From: Holly Duncan
Sent: Tuesday, June 28, 2011 2:16 PM
To: Jeff Watson
Subject: RE: BL-11-00011 Olexsy

From: Jeff Watson
Sent: Thursday, June 23, 2011 5:02 PM
To: Christina Wollman; Brenda Larsen; Jan Ollivier; Holly Duncan
Subject: BL-11-00011 Olexsy

**OLEXY PROPERTY**

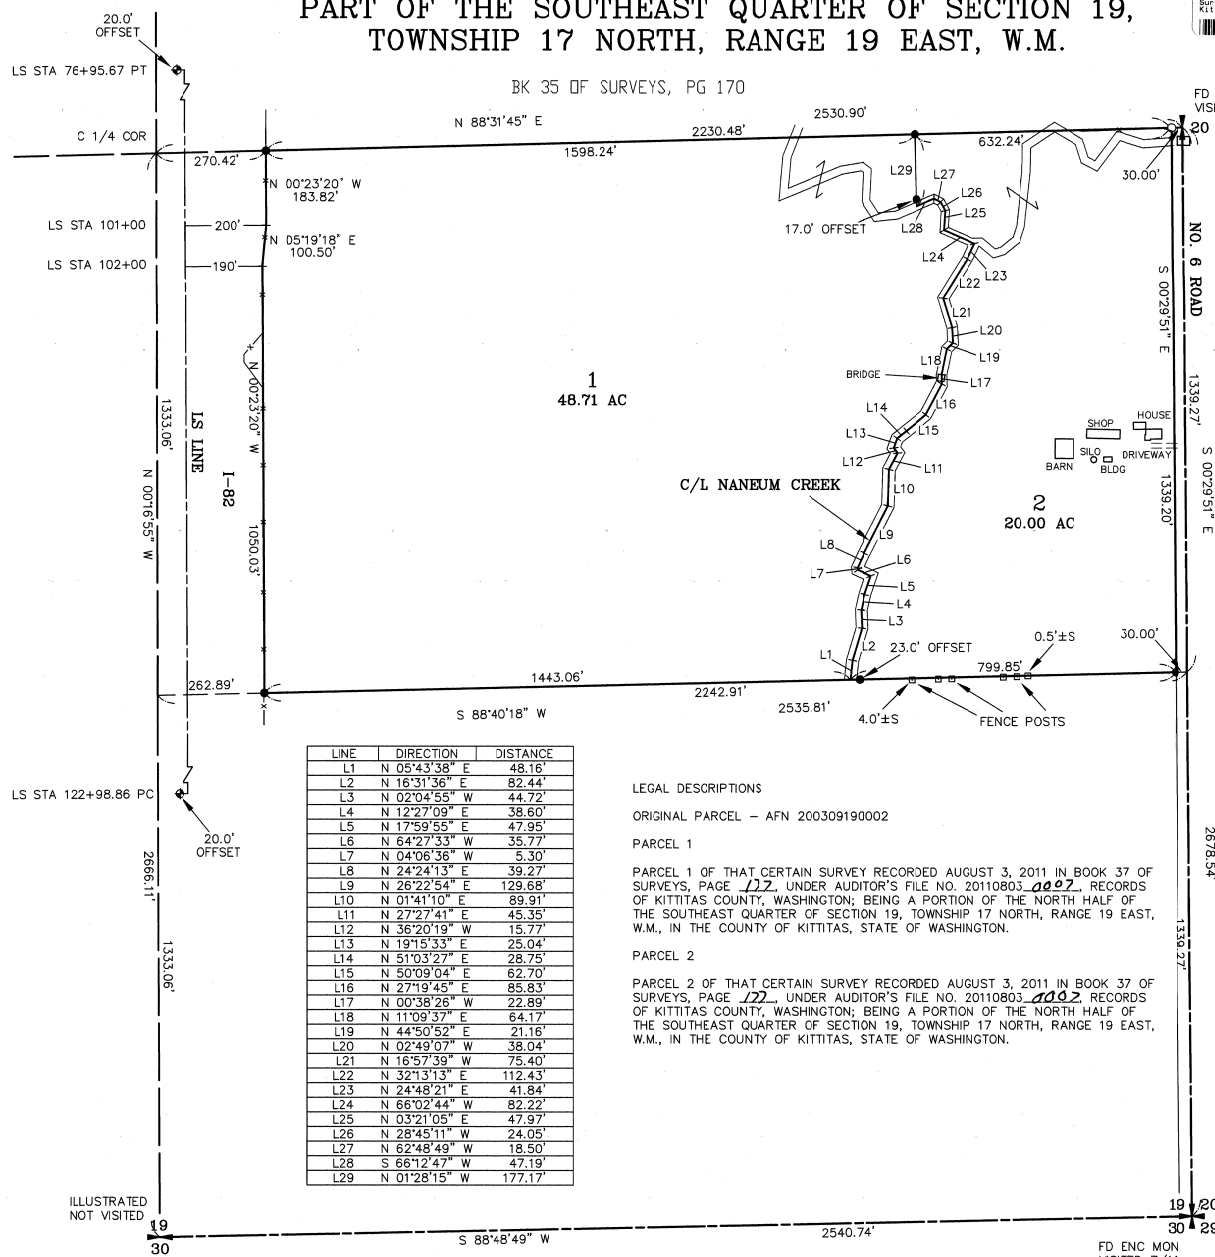
This looks fine as long as wells are at least 50 feet away from the proposed property line.
